DOC18/435021

I refer to your email of 23 April 2018 to the NSW Environment Protection Authority (EPA) regarding Santos' Narrabri Gas Project's Environmental Impact Statement (EIS) Response to Submissions (RTS). The EPA has reviewed the RTS, focusing on Santos' responses to the matters raised in our 1 June 2017 advice to the Department of Planning and Environment (DPE) regarding the EIS. Following detailed technical assessment by specialist staff, the EPA is pleased to provide the following advice.

Figure 28-1 Estimated volume of drill cuttings per year

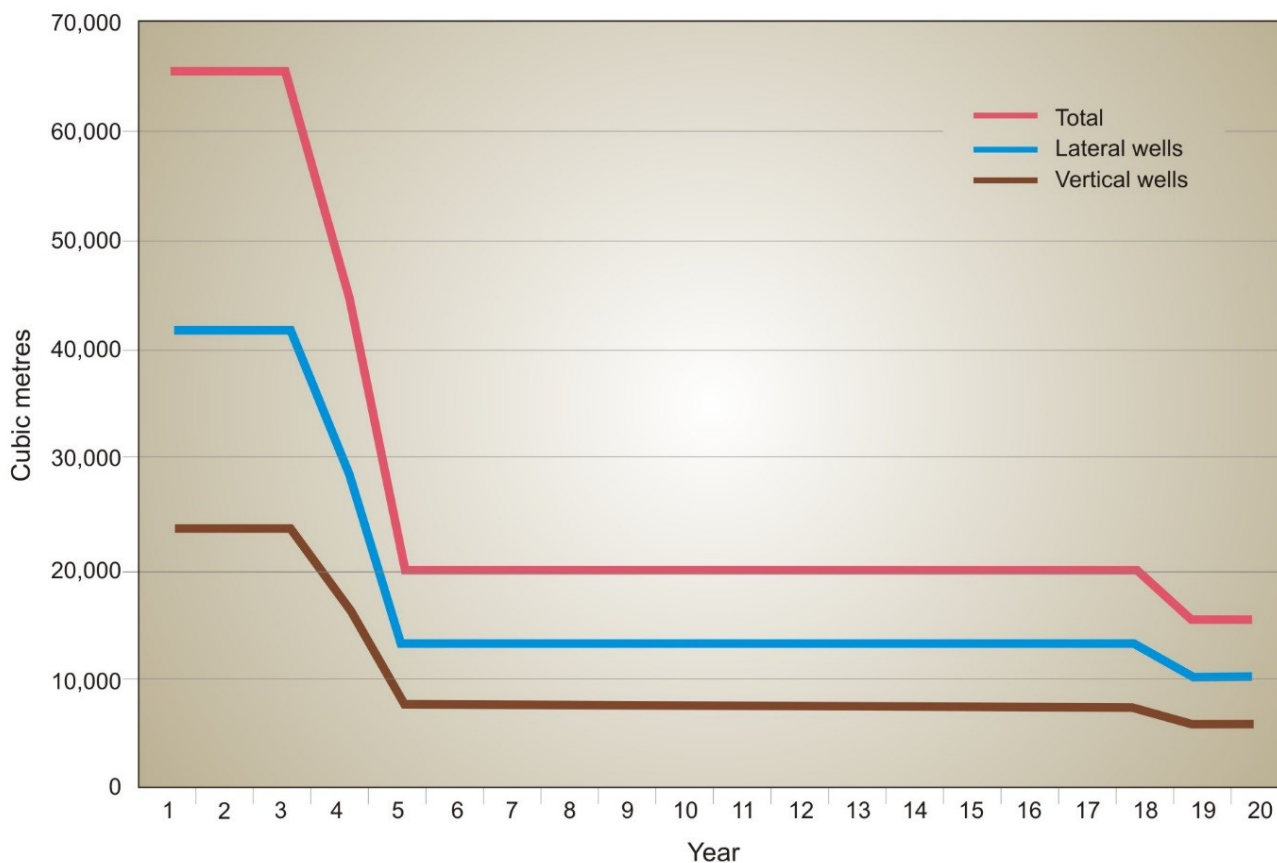
Comment on RTS: The RTS provided some additional information, mostly regarding the separation of coal-based and other drill cuttings. However, not all requested information was provided. The EPA has concerns regarding the management of non-coal drill cuttings at the drill pad sites, specifically the suitability of this material for the use on well pads. This is important to consider to ensure long term rehabilitation and revegetation outcomes are met. Santos indicate that they intend to reuse non-coal cuttings by land applying those on the pad site using a “mix, turn, bury” strategy. The RTS did not provide any detail on what the strategy entails or how Santos will determine suitability for reuse under the strategy.

Recommendation: The EPA recommends DPE request from Santos further information fully describing the “mix, turn, bury” strategy, prior to project determination. Additionally, the EPA recommends that DPE request further detail from Santos regarding determining the suitability of using non-coal cuttings at drill pad sites. The EPA also recommends DPE request Santos conduct ongoing monitoring of this material over the life of the project to continually assess the suitability of using this material at drill pad sites as part of a waste management plan.
